From [REDACTED]
Sent: 30 December 2019 11:46
To: Planning.Responses <Planning.Responses@arun.gov.uk>
Subject: A/122/19/OUT Land off Arundel Road, Angmering BN16 4ET

Our Ref: NW/ARU/18/05C

Date 30th December 2019

RE: Land off Arundel Road, Angmering BN16 4ET

Figure 5.2: Illustrative Masterplan.

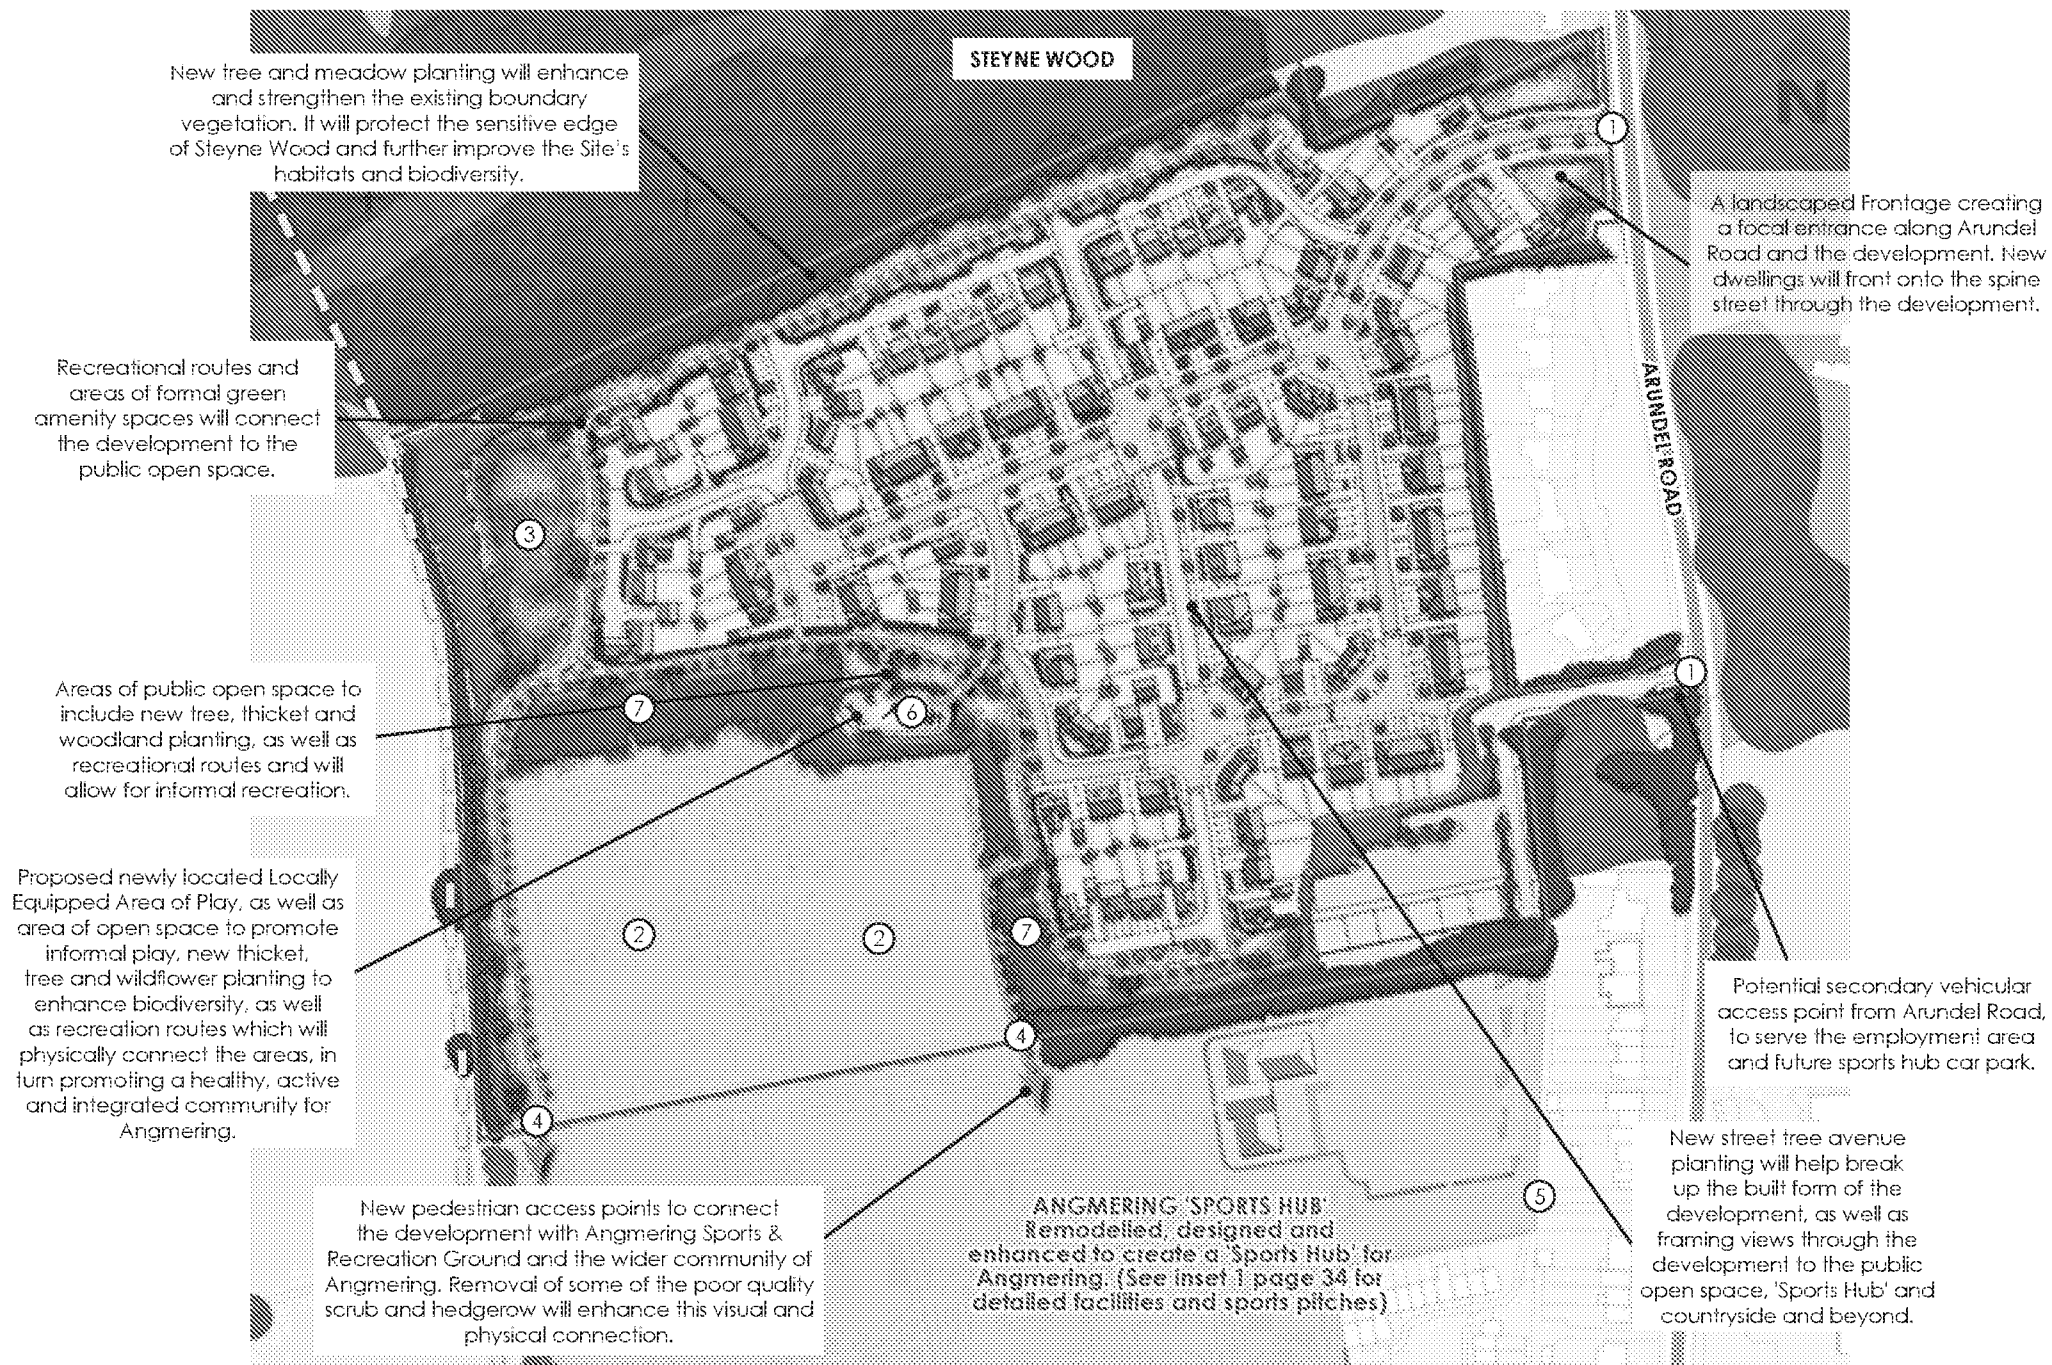
I also note the addition of a LAP in the north east corner of the development which is close to the main access road, and although visible from the road, it is not particularly overlooked by any nearby dwellings. I have a slight concern about its position within the development , and reiterate my previous comments that any potential areas of play should be situated in an environment that is stimulating and safe for all children, be overlooked with good natural surveillance to ensure the safety of users and the protection of equipment, which can be vulnerable to misuse. I would recommend that the eventual location is surrounded with railings with self-closing gates to provide a dog free environment and prevent very young children being able to run into the road.

Provision should also be made to prevent the access of vehicles and motor cycles using the perimeter pedestrian recreational route or accessing the south side of Steyne Wood.

A row of trees are indicated along the north side of the access road adjacent to the LAP. Any planting should not impede the opportunity for natural surveillance and must avoid the creation of hiding places where it would provide cover for criminal activities.

Bushes should be clipped not to exceed one metre in height. Any trees should have their undercrofts no lower than two metres to allow a view between.

I also note the SuD located at the north-west corner of the application. This again should have a barrier to prevent vehicles accessing it as it is located at the turning area at the end of the road. If the SuD remains water filled during the year, consideration must also be given to preventing accidents and access by young children.

Access to the sports hub and pitches parking area at the south-east corner of the development is jointly shared by the Commercial Development and the proposed Angmering Sports Hub. There must be adequate separation between pedestrians, cycles and vehicles along the access route to avoid conflicts between the three.

To the immediate east of sports pitch 3 there is an access point through the hedge which can be reached via roads leading south from the main access road. This has the potential for players and spectators to park vehicles and congregate rather than use the sports hub car park and congest the junction at certain times as it leads more directly onto the playing pitches.

Although the commercial unit will be screened by bushes and trees to reduce noise and visual impact on the residential areas, good natural surveillance from nearby dwellings would provide an additional crime deterrent, and so careful planting will be required to provide both.

This would also be a consideration for the Sports Hub and Muga when the premises are closed and during the hours of darkness. As the west side of the Sports hub in particular will be out of sight from surrounding residential properties. Alternative measures such as intruder alarms and CCTV will need to be considered for both Sports Hub and Commercial Units.
